**IN THE MATTER OF AN APPLICATION TO
AN BORD PLEANALA**

**For Approval of the Railway (Metrolink – Estuary to Charlemont via
Dublin Airport) Order [2022]**

ABP-314724-22

Schedule of Errata

### Alignment

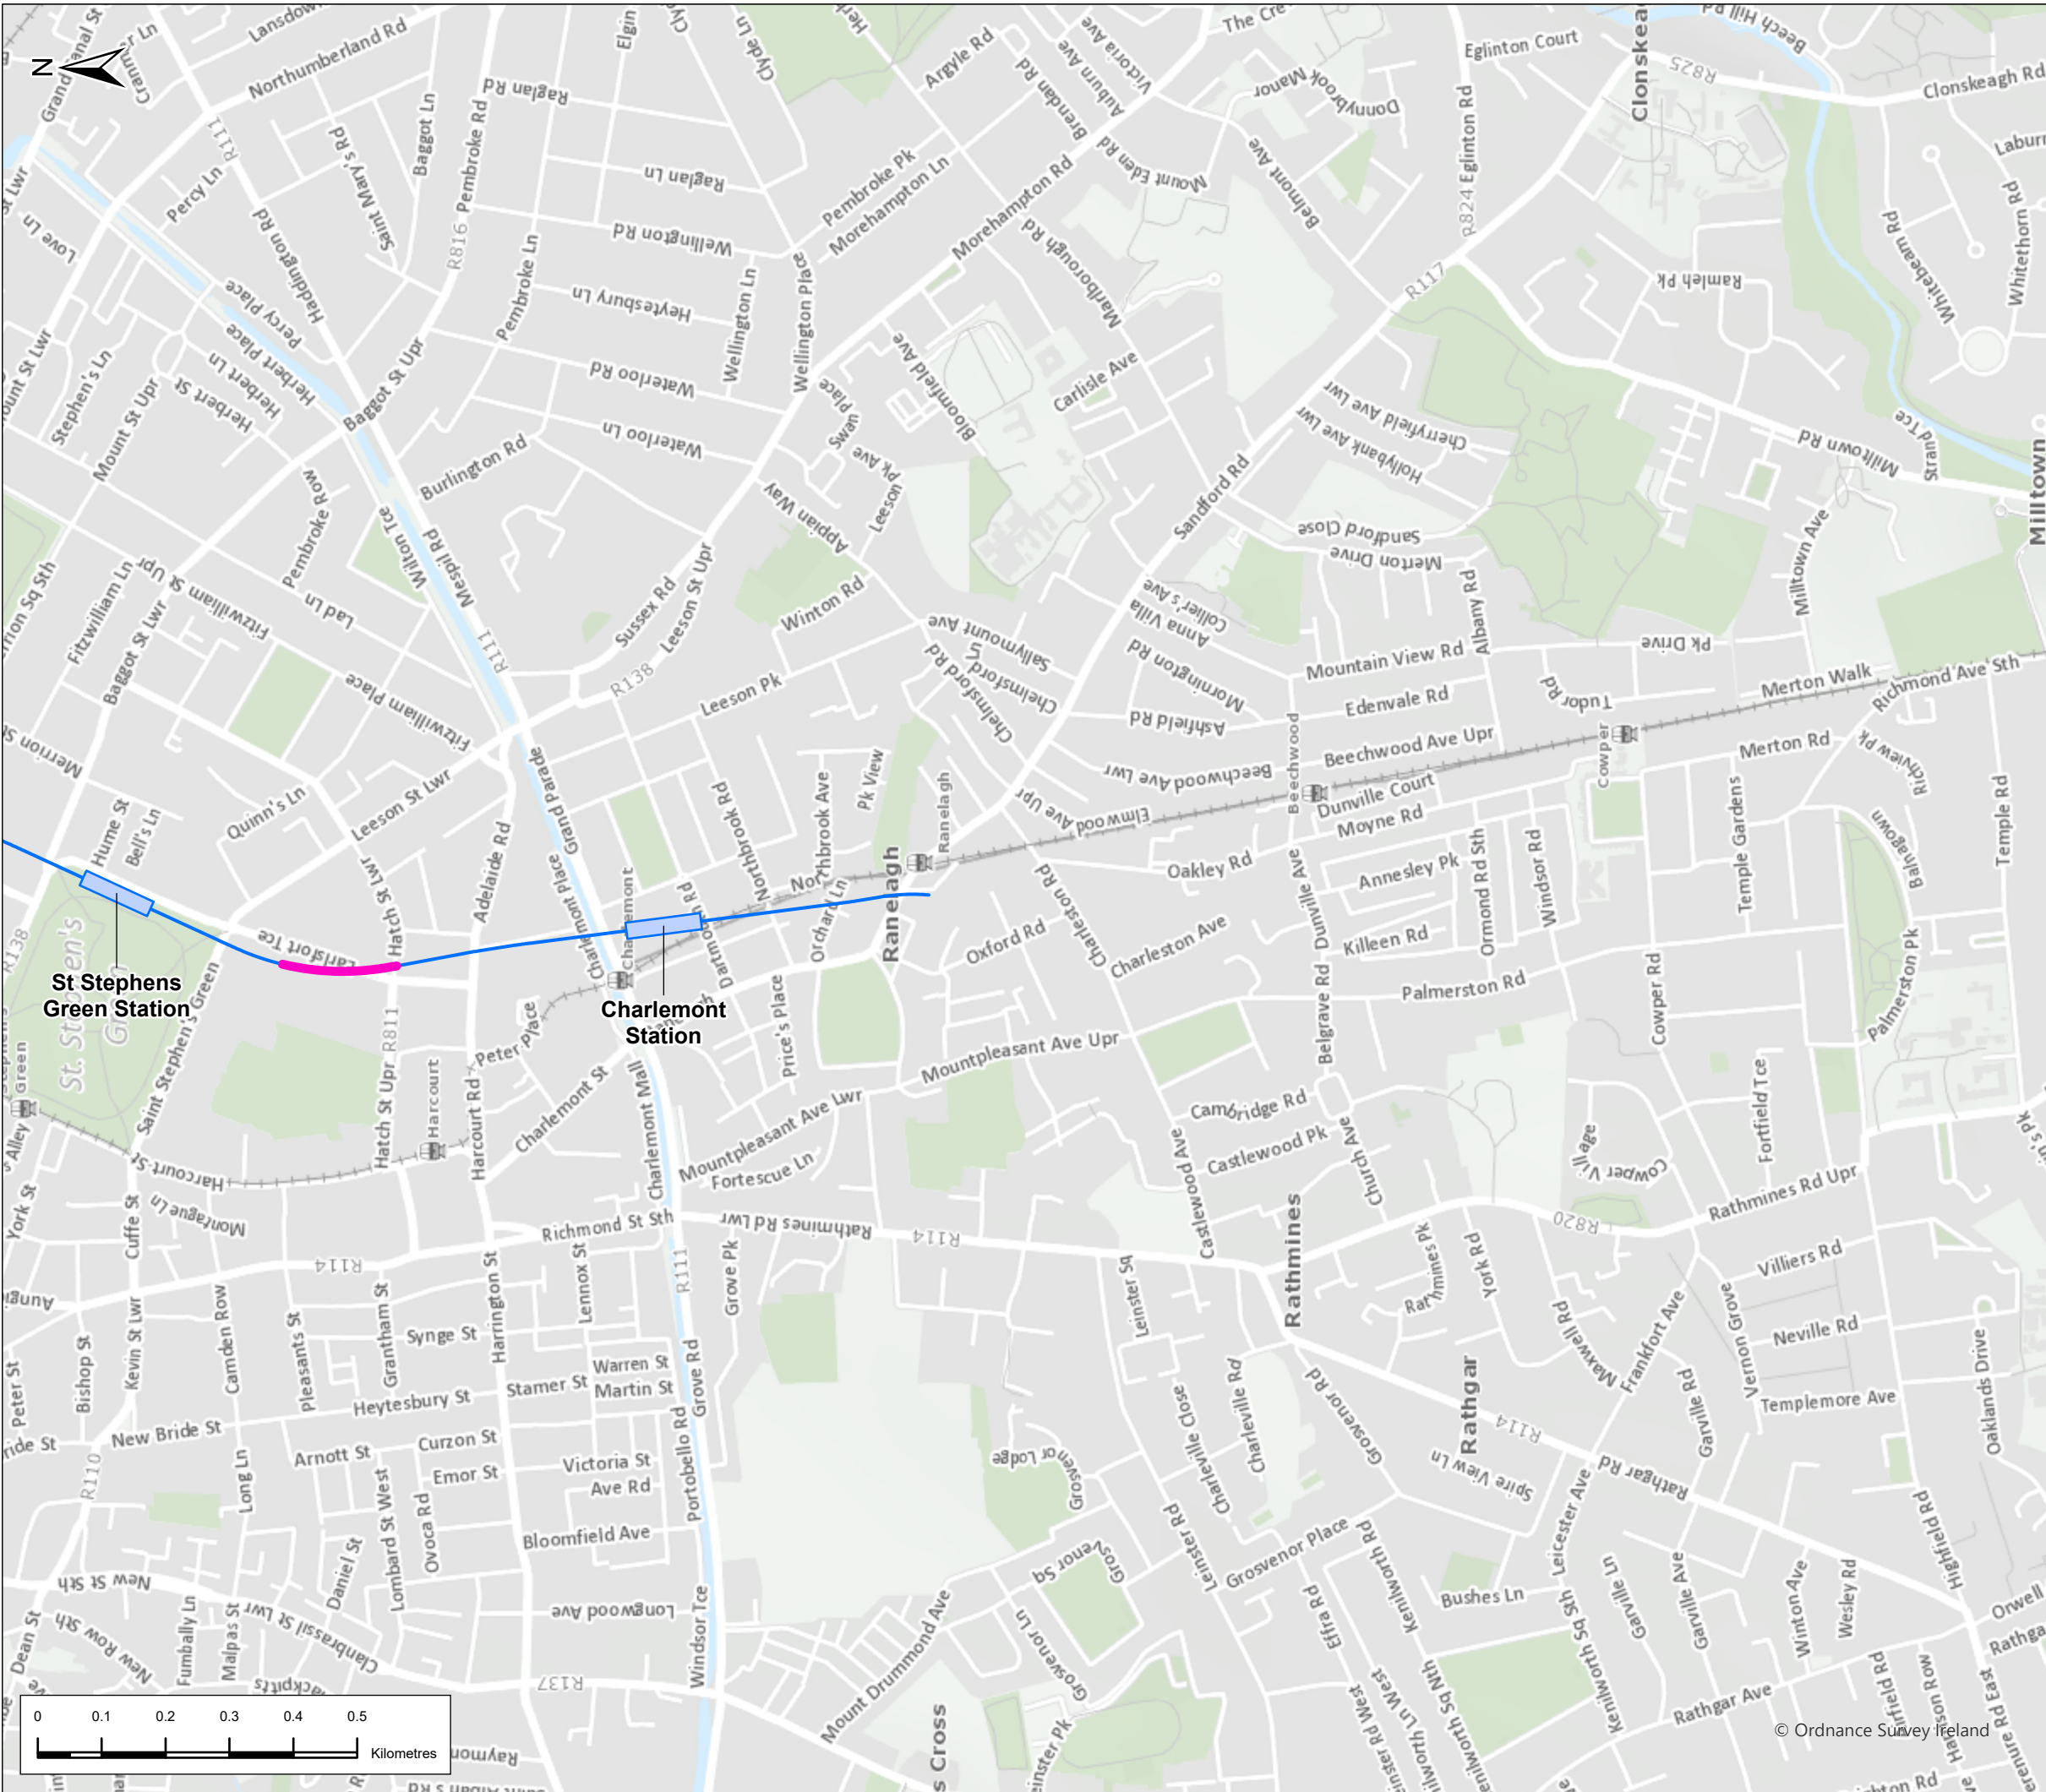
37.	EIAR Chapter 14 Groundborne Noise and Vibration	n/a	n/a	Additional Figure, showing proposed locations for Floating Slab Track	Additional Figure, showing proposed locations for Floating Slab Track. Please refer to Appendix 12 Updated and Additional GBNV Figures.
